DAVID KIBBLE WINES

Maltravers Road B.N17-5LF. WA/114/18/HH.

I am writing ~~of~~ to OBJECT to the above planning application.

Proposed Ground Floor Plan

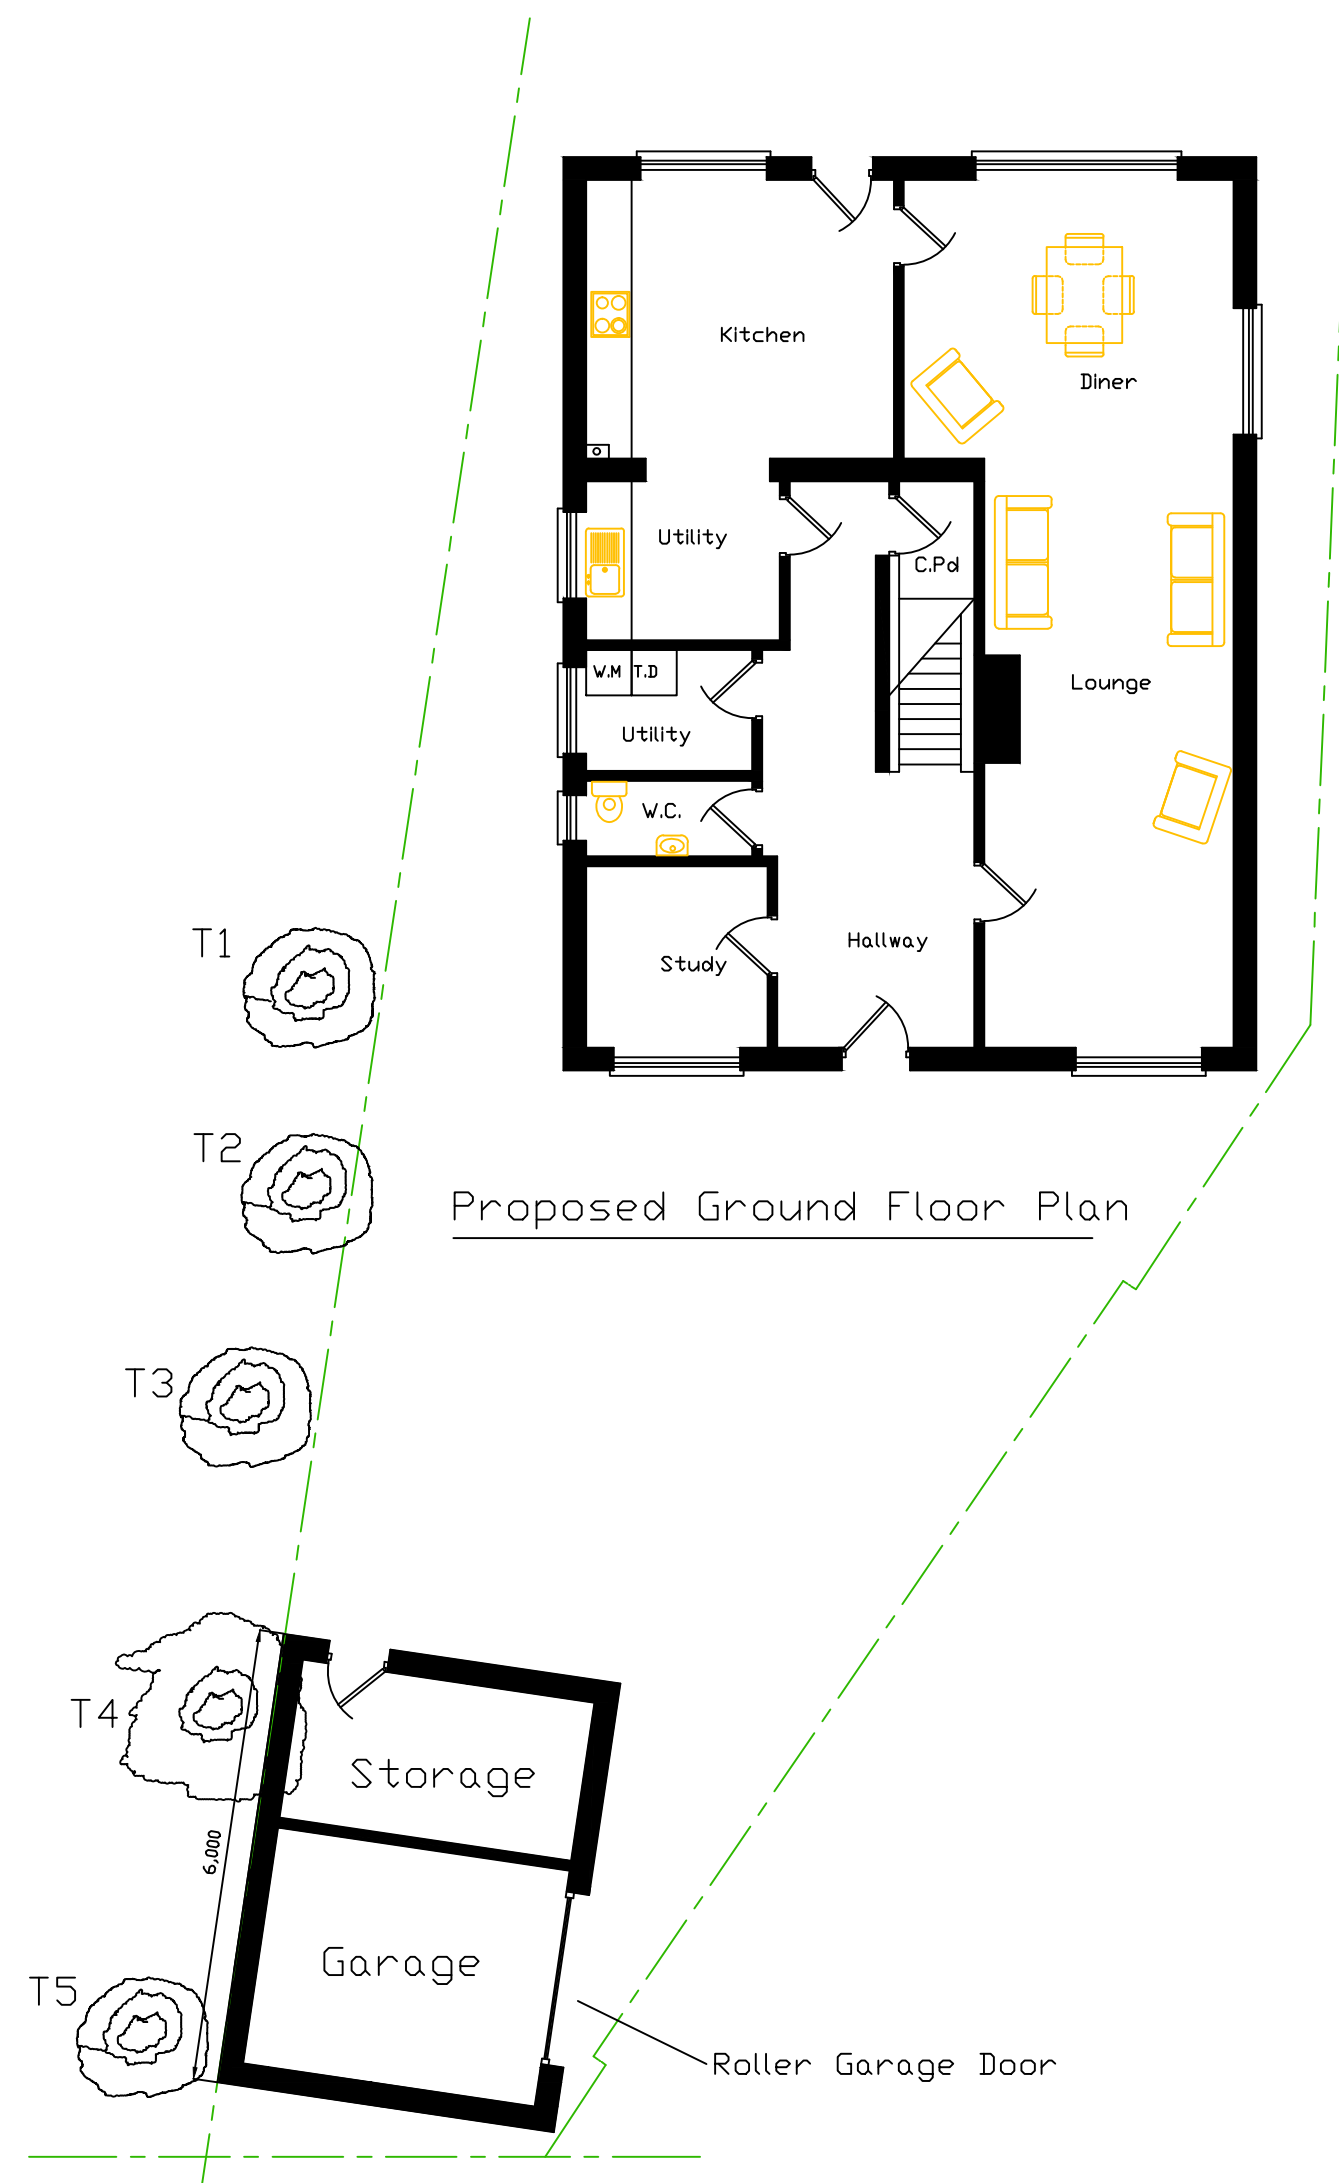
I feel that the design protrudes significantly forward, a marked departure from the established building line.

Rev./A 27-12-2018 Scale Bar Added and Post Code Corrected	
 Tel:- 01243 555208 enquiries@extendinghomes.co.uk	
TITLE:- Garage & Front Porch @ 5 Orchard Crescent Fontwell West Sussex BN18 0SD	
DATE:-	30th November 2018
SCALE:-	Garage Plans & Elevations 1-50
DRAWN:-	P.Robinson
DWG. No. 1811301/PL/4A

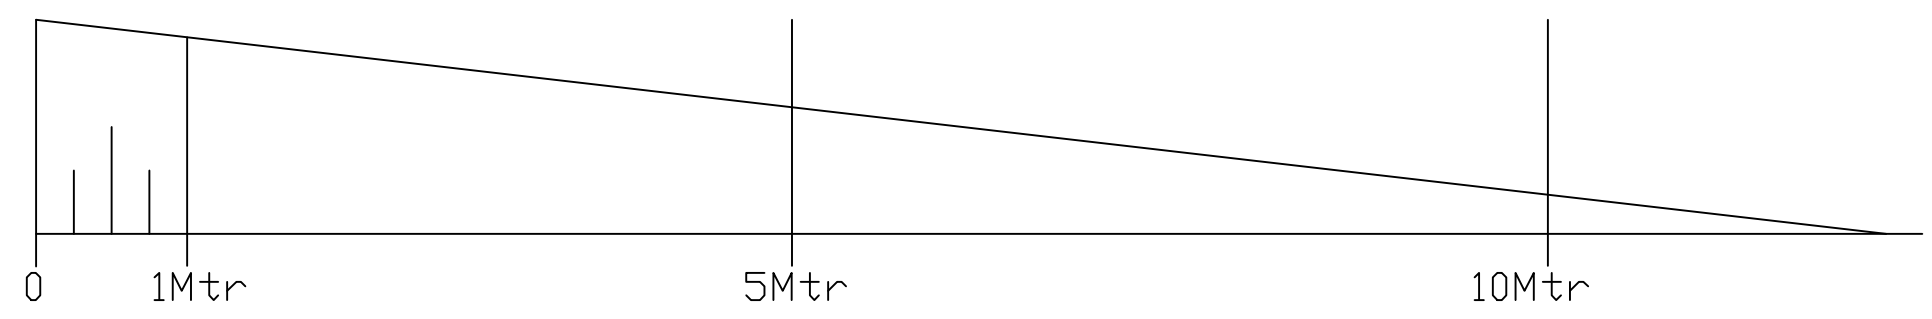
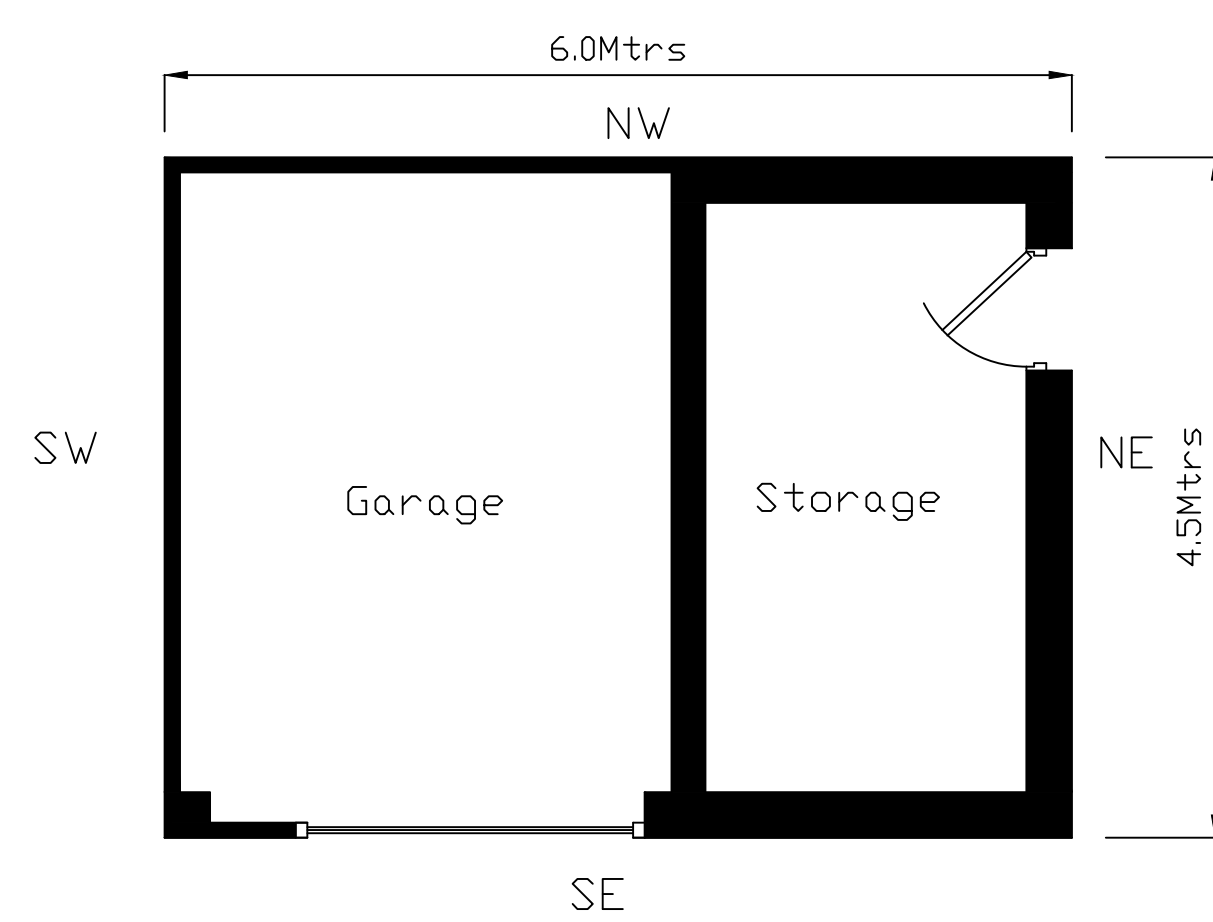
My key concern is with the garage/store that is proposed. While there is already a garage/store situated to the front of the property, the new structure utilizes a completely new access. With parking on both sides of the road close to the shop's and often around the corner (on the southern side) I feel that the new access into the Garage could be problematic. The current arrangement with access close to the property is fine, but the removal of ledgers for the new garage access

Will no doubt cause issues when manoeuvring a vehicle in and out.

There appears to be nothing associated with the application, showing how a vehicle will safely track in and out of the garage bearing in mind the unrestricted parking ~~in~~ Orchard Crescent.
